# SCHOOL DISTRICT 49

## GROUNDS EXPANSION

## DEVELOPMENT PLAN

JANUARY 28, 2025

D49 CENTRAL OFFICE GROUNDS
 DEVELOPMENT PLAN (North Half)
 1080 E WOODMEN RD.
 FALCON, CO 80801

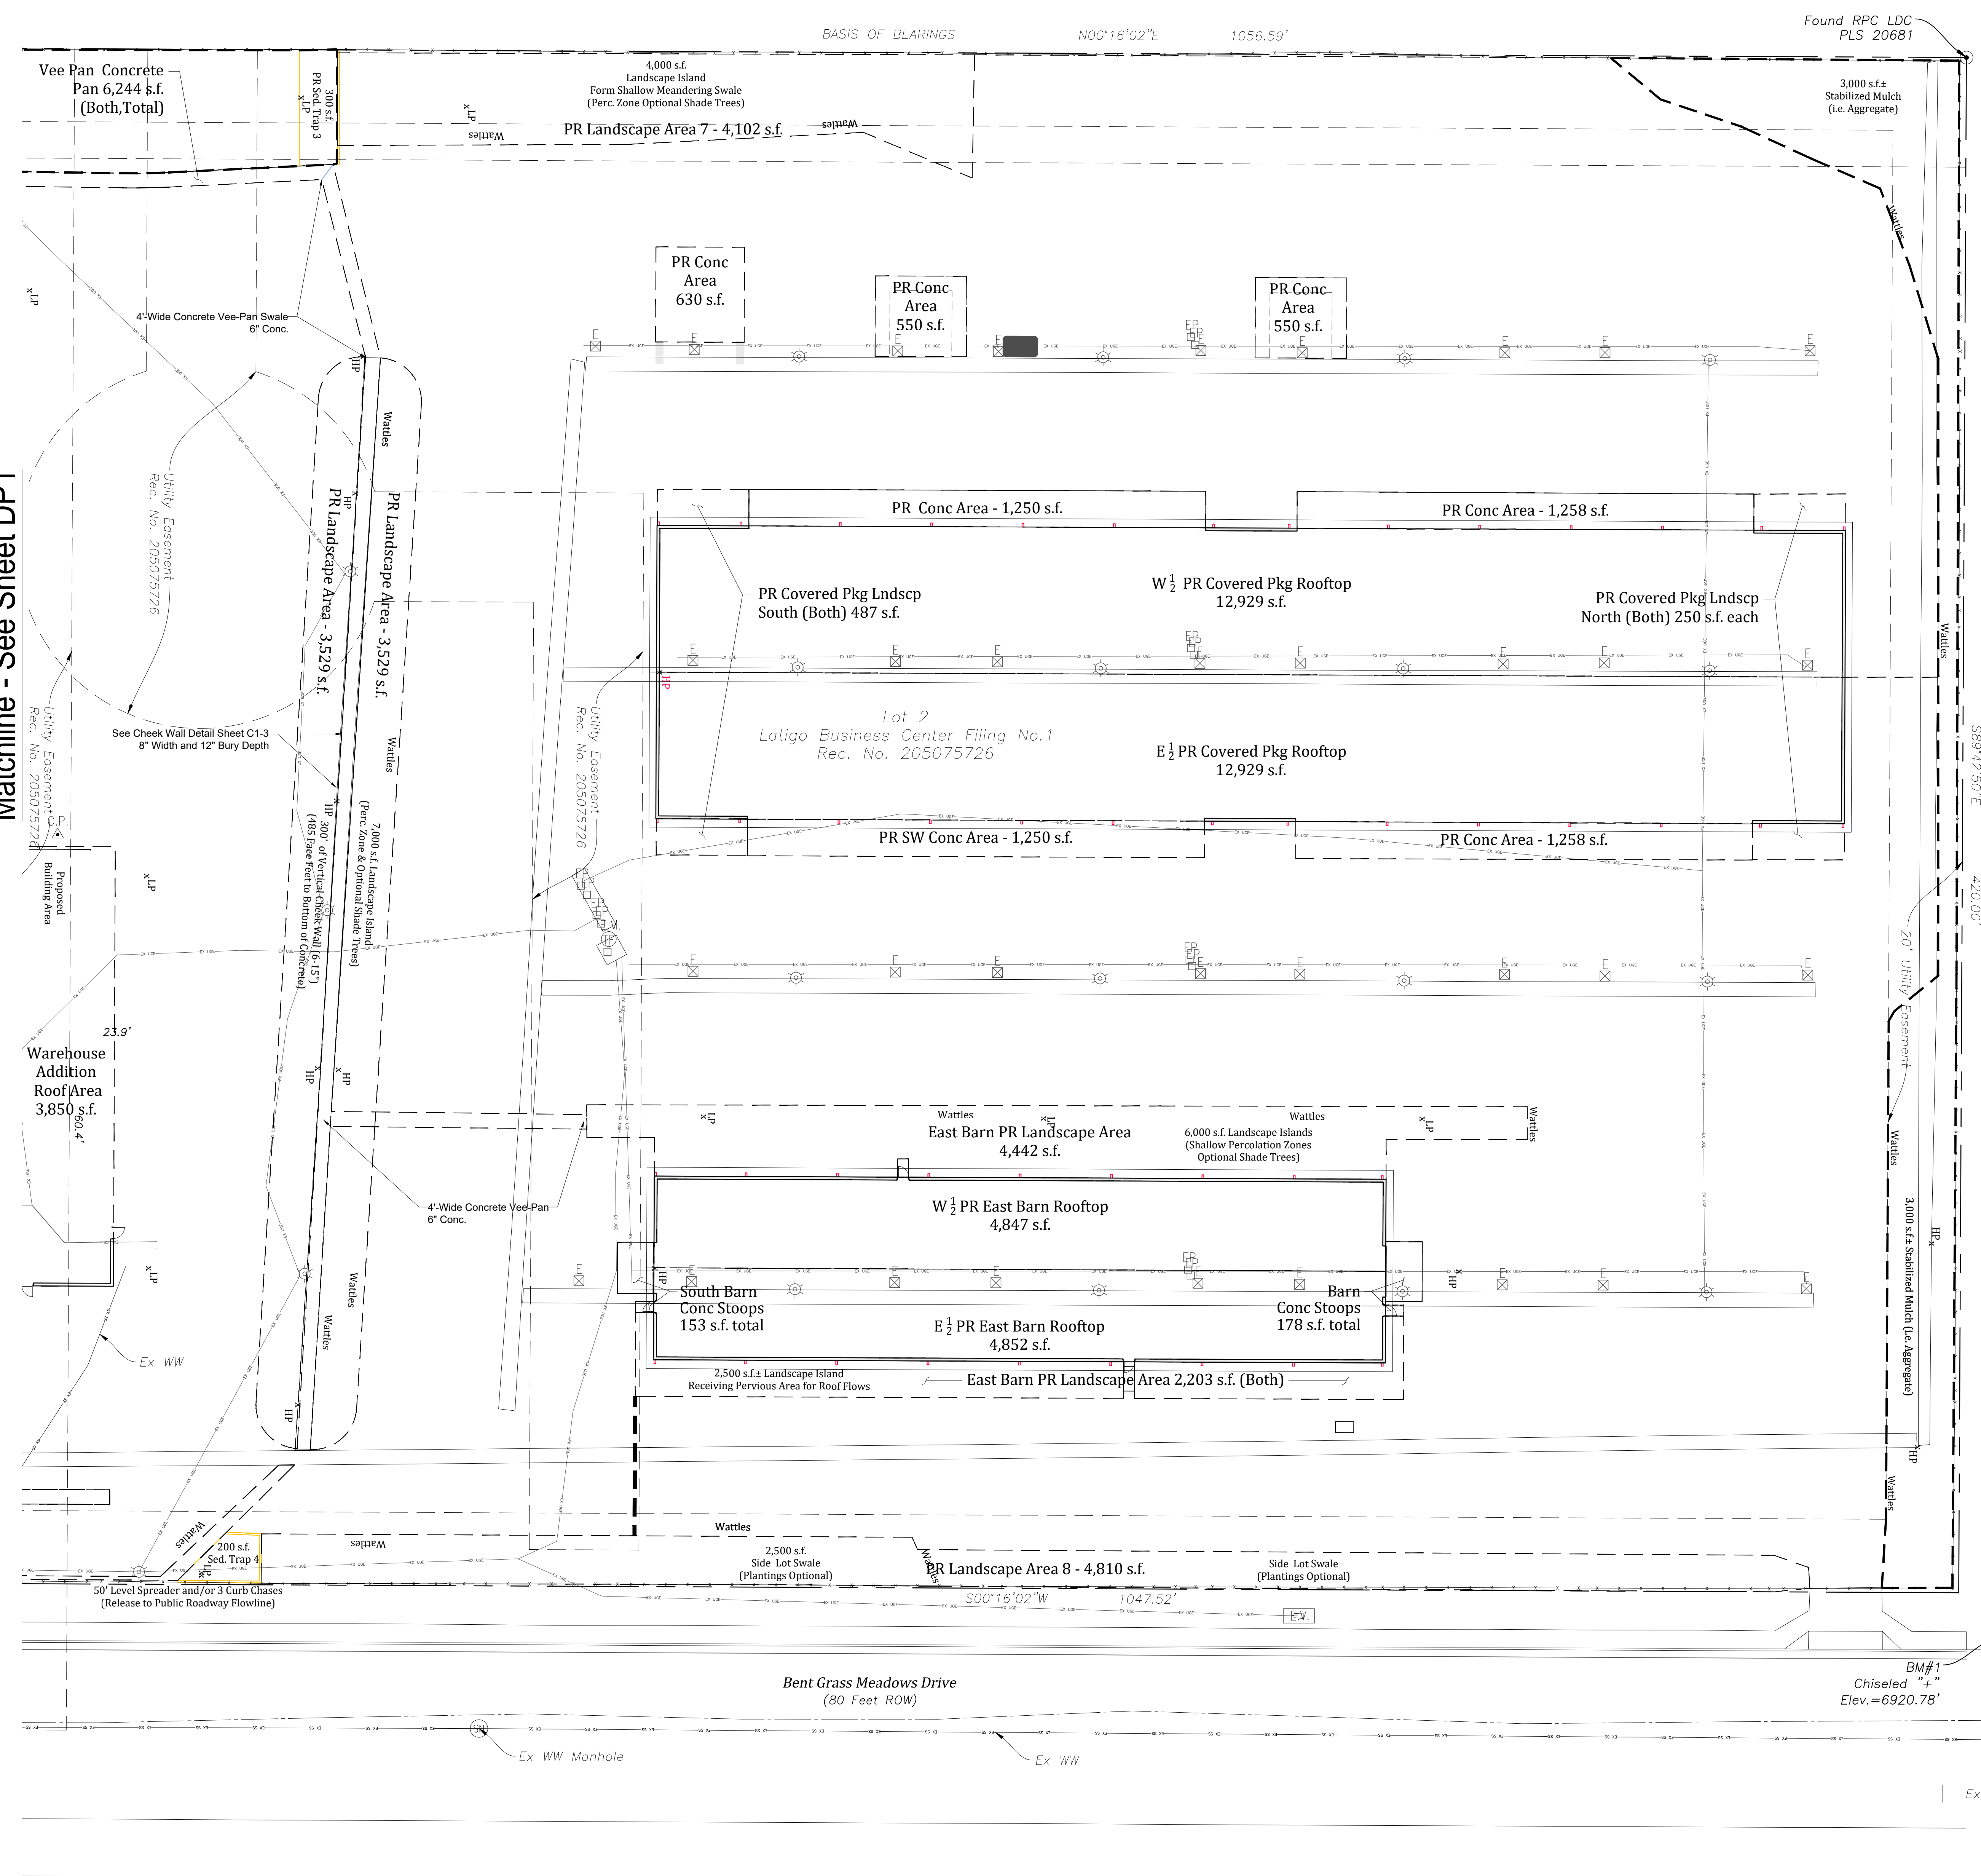
Please depict points of ingress/egress and proposed traffic flows throughout the site
